May 16, 2022

**Subject: Coffee Shop – Brayton Road Traffic Impact Study  
NM 45 (Coors Blvd.) and Brayton Road – northeast corner  
Albuquerque, New Mexico**

This letter is to inform you that the **FINAL** Traffic Impact Study (TIS) for the proposed Coffee Shop – Brayton Road on the northeast corner of NM 45 (Coors Blvd) and Brayton, dated March 29, 2022, has been reviewed.

SHEET TITLE
ARCHITECTURAL
SITE PLAN

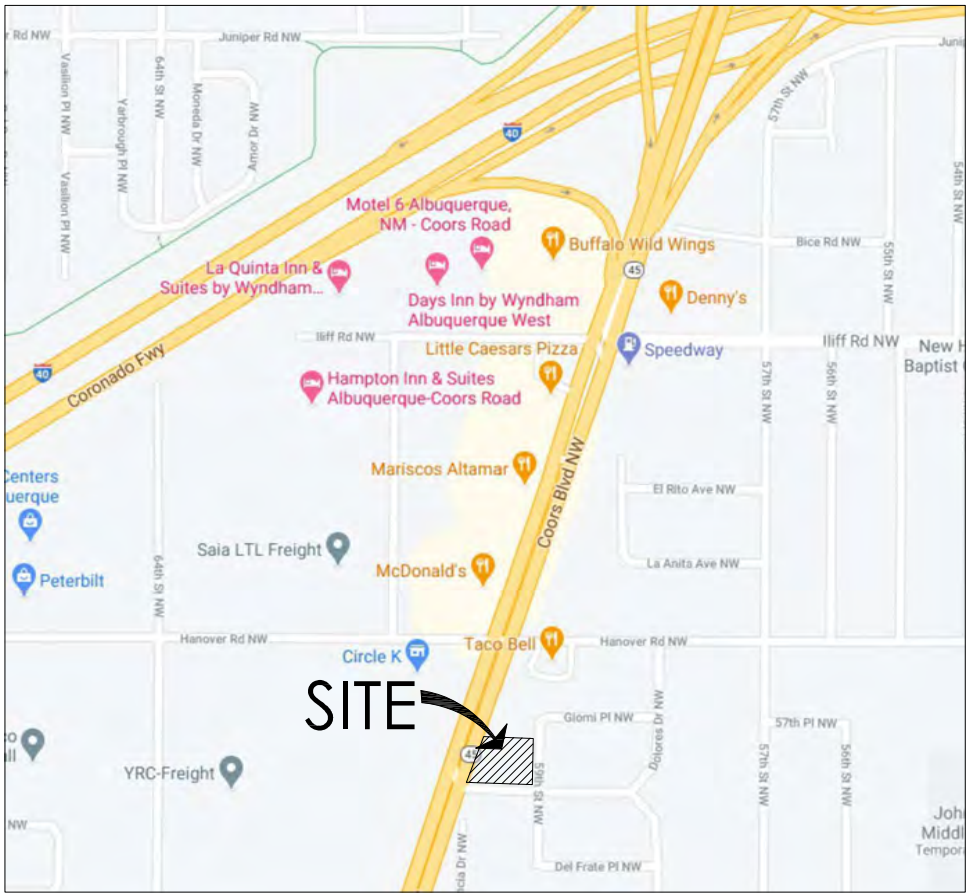
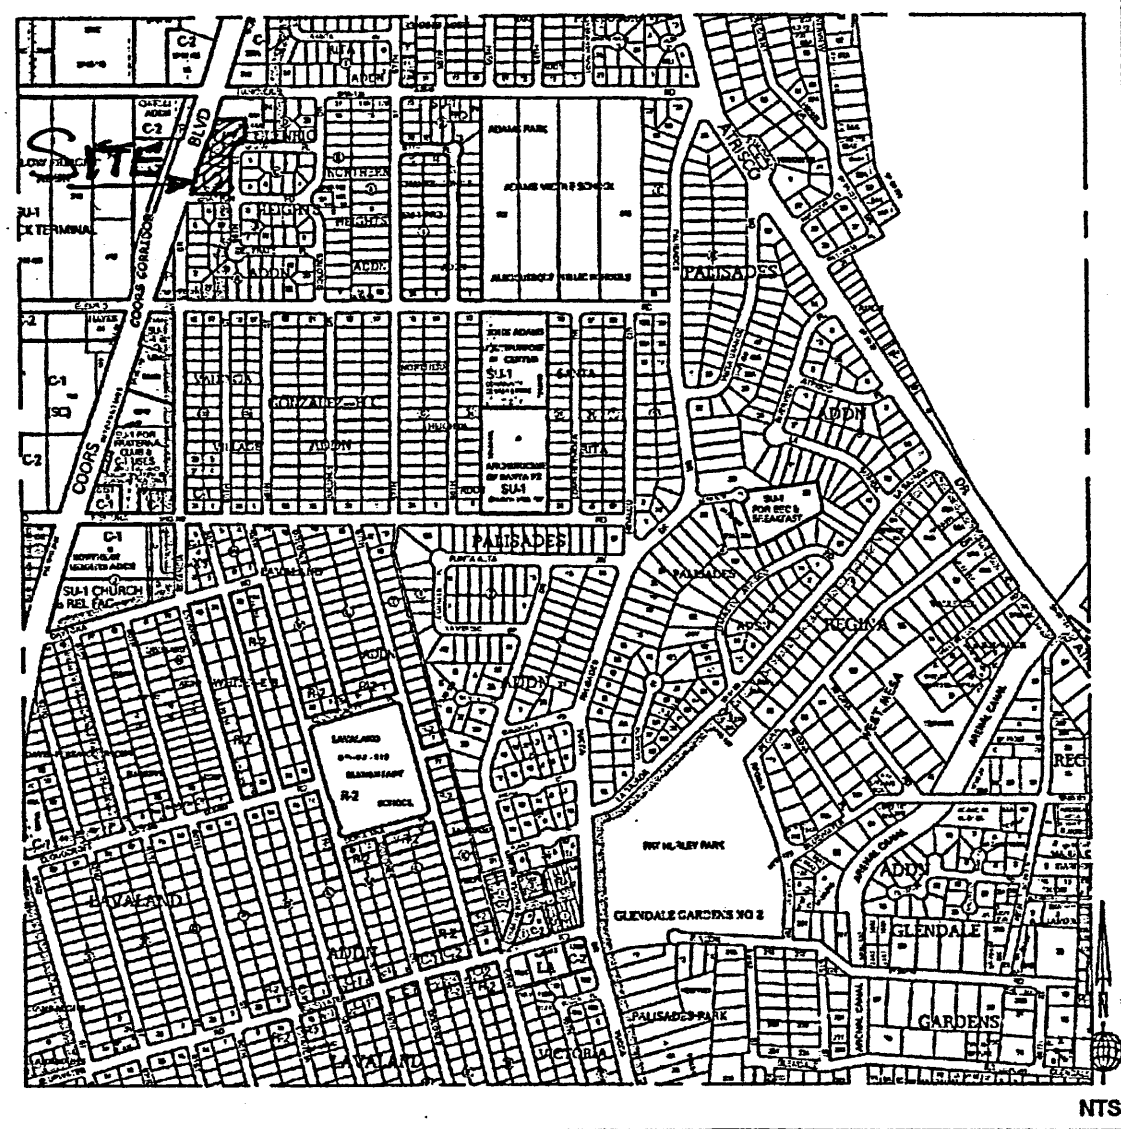
The NMDOT has no objection to utilizing the Right-in/out and Left-in partial access at Brayton Road. Please see Exhibit A for the proposed site plan and its access point location. This study has been finalized and its recommendations are attached. See Exhibit B for the Summary of Recommendations. NMDOT gives final concurrence of this development given the conditions below are met.

1. The development shall design and install a northbound right turn lane on NM 45 at Brayton Rd at a total length of 350-feet including taper.
2. The NMDOT shall provide final approval on the design for the offsite improvements. The developer shall agree to incorporate all the comments requested by the NMDOT.
